Our ref: P01395490

20 December 2021

**T&CP (Development Management Procedure) (England) Order 2015
& Planning (Listed Buildings & Conservation Areas) Regulations 1990**

**HINCHLIFFE MILL, WATER STREET, HOLMBRIDGE, HOLMFIRTH, WEST
YORKSHIRE HD9 2NX
Application No. 2021/90800**

HOUSE TYPE : UNIT 18

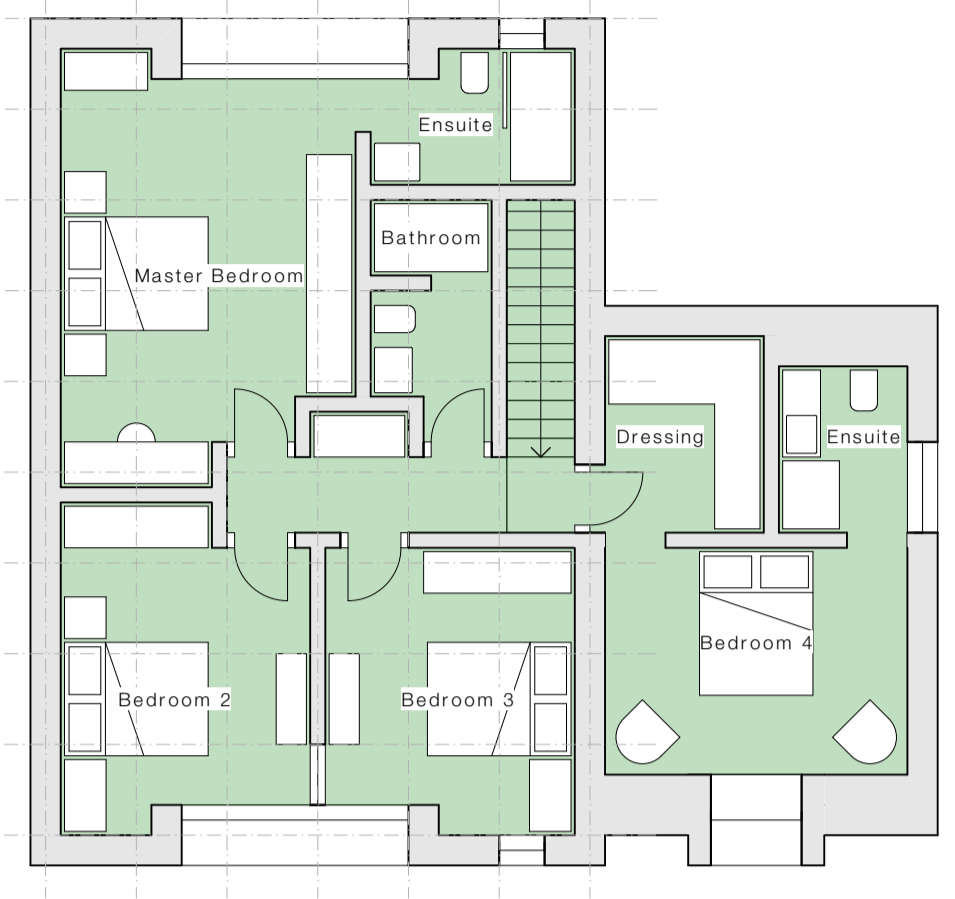
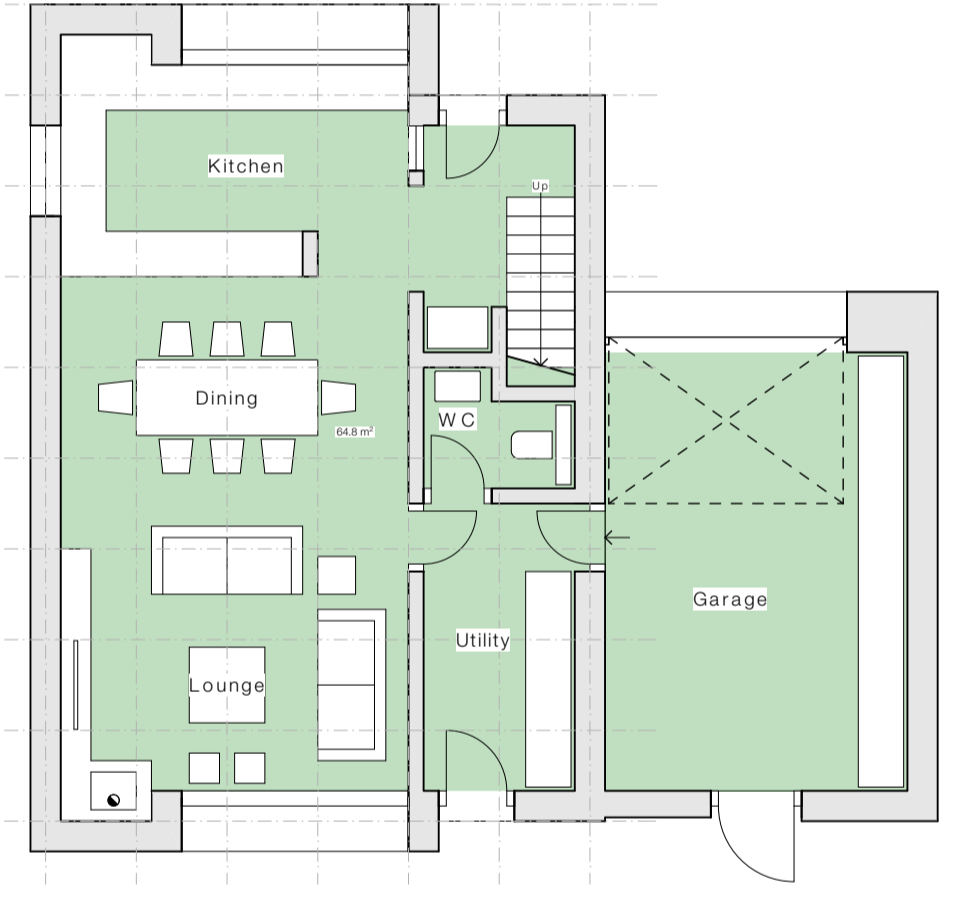
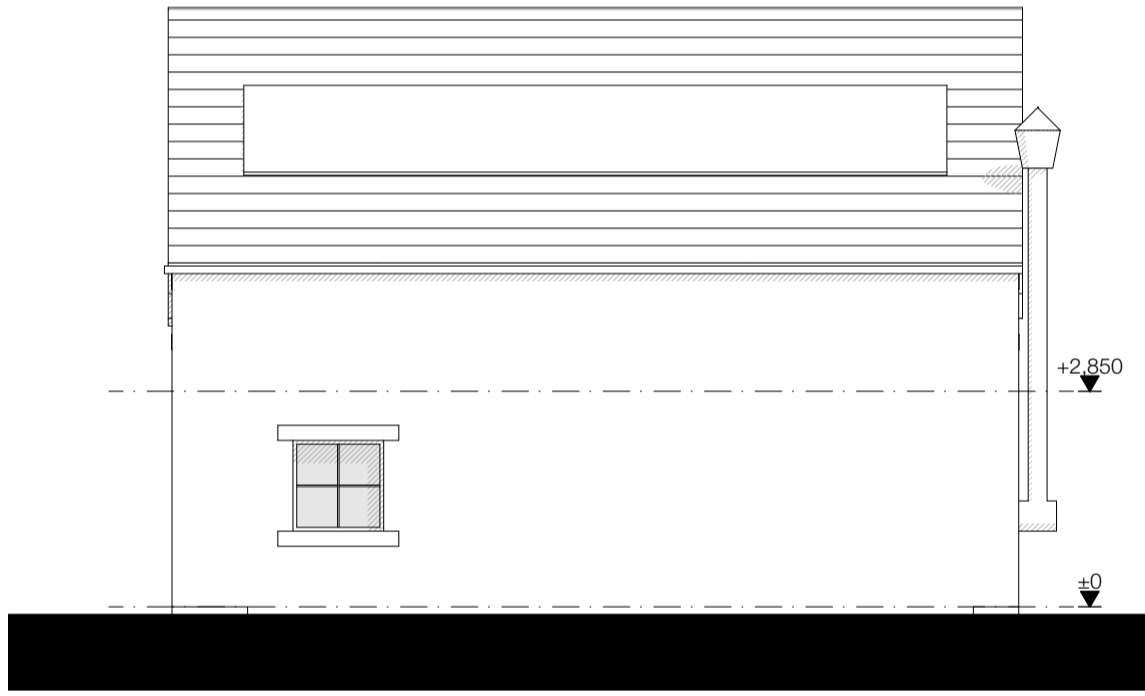
The amendments to the houses at the southern end of the site (revised to units 17, 18 and 19) are also welcome as these reduce the impact on the setting of the mill in views from the north, situated as they are on higher ground above the mill.

mill and the conservation area from the south and the additional information has not furthered an assessment of this impact. While we acknowledge that a modern large shed occupied this part of the site, it was much lower and its massing more recessive in views of the conservation area from the south. The removal of the shed, reinstating lost views of the mill, was a clear enhancement to the setting of the conservation area and the non-designated asset. Therefore, we consider this is a very sensitive area for development, and in determining this application we recommend your authority assess the impact of the proposals in views towards, as well as from, the conservation area. Additional information or CGI/ photomontages may assist in this assessment.

In summary, we welcome the amendments that have been made to the proposals but we still have some concerns about the impact of the three large detached dwellings to the south of the site (units 17, 18 and 19). In determining this application your authority should consider the impact of the proposals on the character and appearance of the conservation area and the justification for these three units given that they increase the impact of the development on the conservation area and setting of the mill complex. This is in accordance with paragraphs 199, 200 and 206 of the NPPF.
